28 May 2012

**RE: Orica Chlor Alkali Plant
Modification Application 35/98 MOD 4**

The Council has received notification from the Department regarding the above mentioned modification application to the Orica Chlor Alkali Plant. The modification application seeks approval for the replacement of two (2) 1.1 megalitre steel caustic storage tanks and demolition of two existing, and currently disused caustic storage tanks at the Botany Industrial Park, Matraville.

Figure 3: Plan of proposed tanks

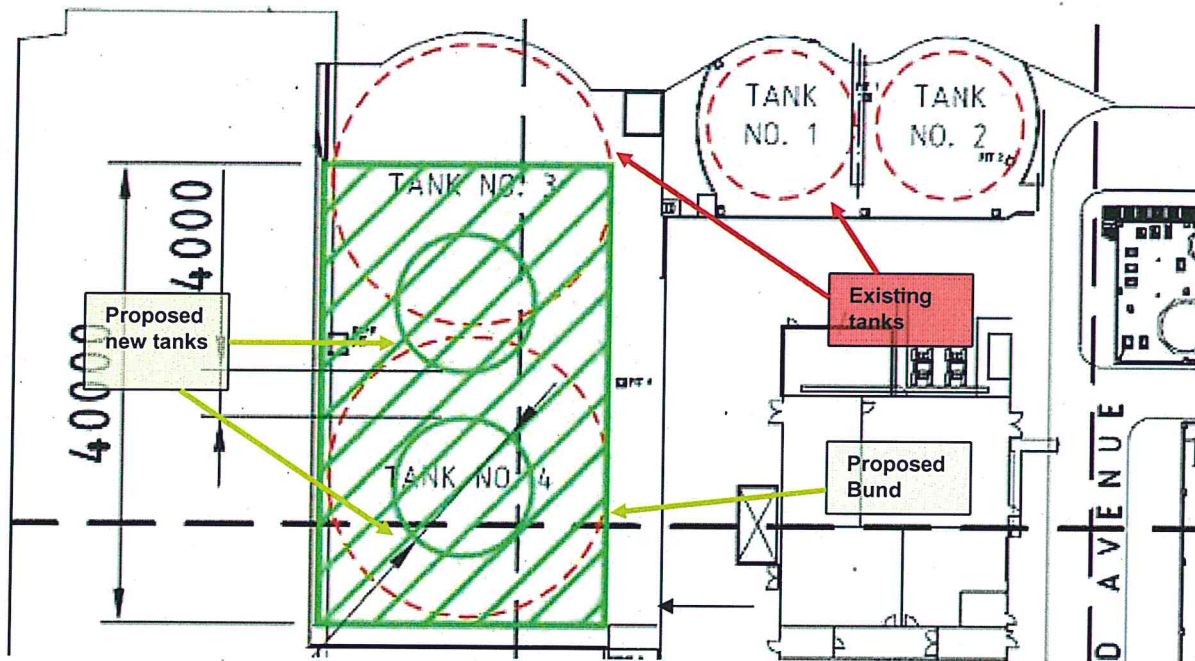
- **Heritage Items** – The Orica's Main Administration Building and the mature Ficus tree (adjacent to this building) are identified as heritage items in the *State Environmental Planning Policy (Major Development) 2005 – Three Ports*. The proposed tanks are located approximately 50-100 metres from the heritage items. Hence, Council recommends a condition be incorporated to the project approval requiring the monitoring of the heritage items during the construction phase.
- **Insufficient Information** – The modification seeks the installation of two new tanks at the former location of Tanks 3 and 4. However, no plan or dimension of the tanks was provided.
